NOTICE TO CONTRACTOR
 APPROVED:
 09/10/2020

DRAWN
 HMP
 DATE
 10-14-2016
 SCALE
 1/4" = 1'-0"
 JOB NO.
 3 CAR DETACHED
 GARAGE & APPT.
 SHEET
 1
 OF FIVE SHEETS

WEATHERLY GARAGE

MAIN LEVEL GARAGE

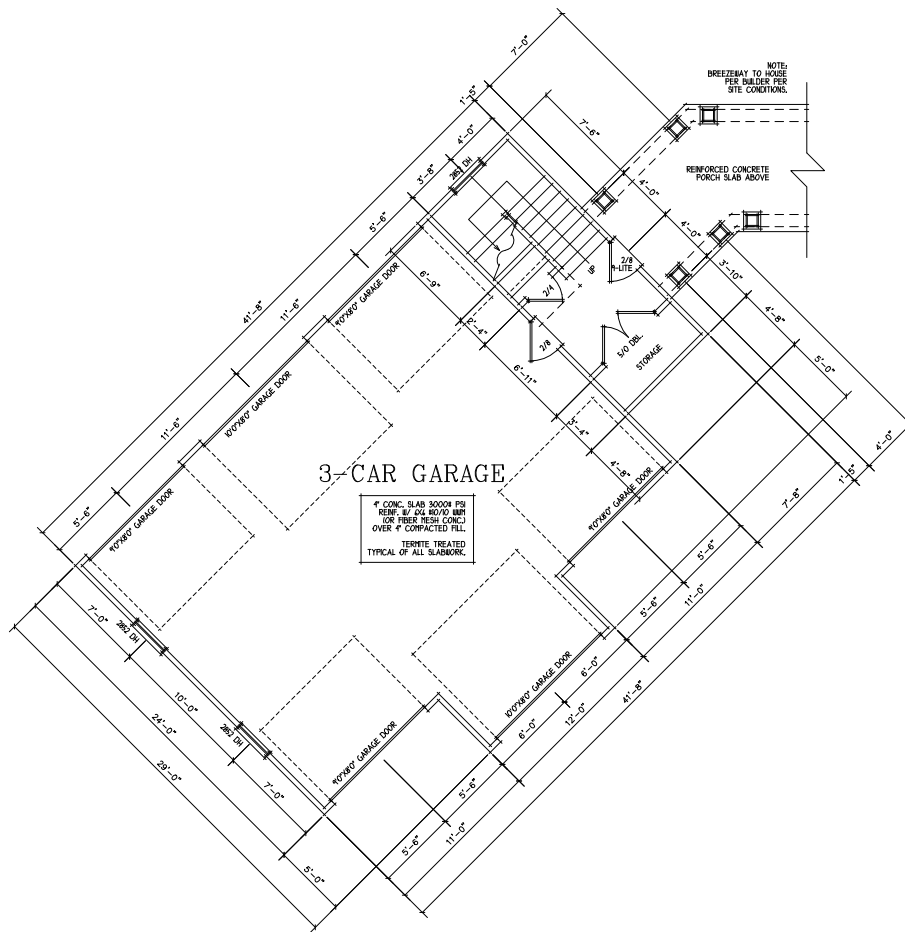
Garage ceiling shall be 5/8 type x minimum. Doors/walls between garage and stair shaft shall be fire rated.

UPPER LEVEL GARAGE
 1/4" = 1'-0"

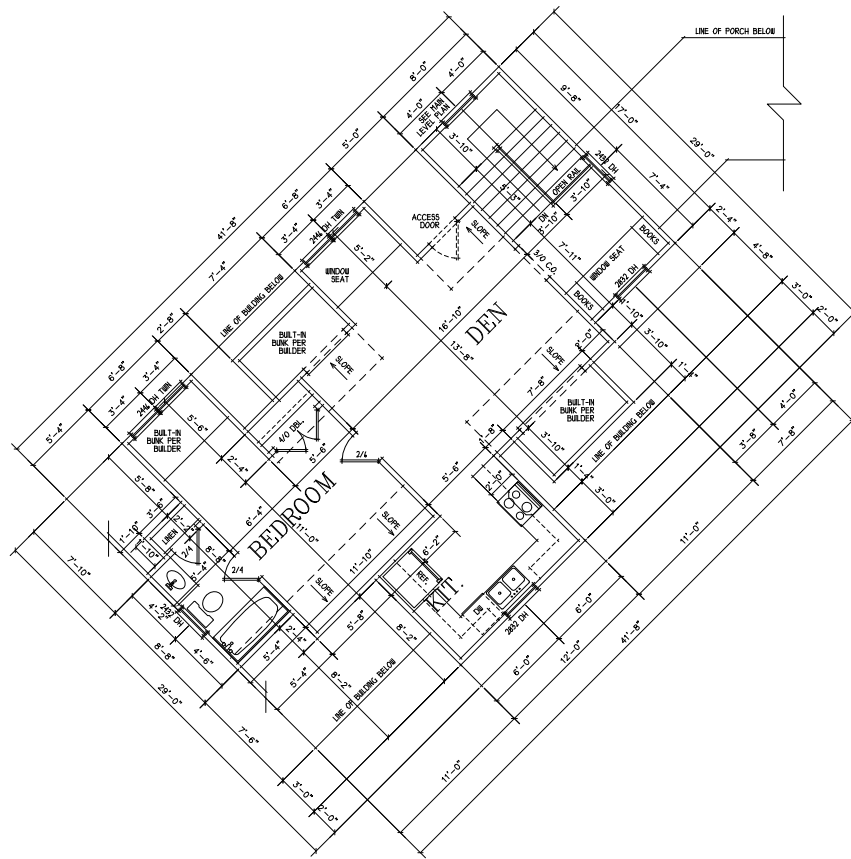
Bunk shall not block egress window
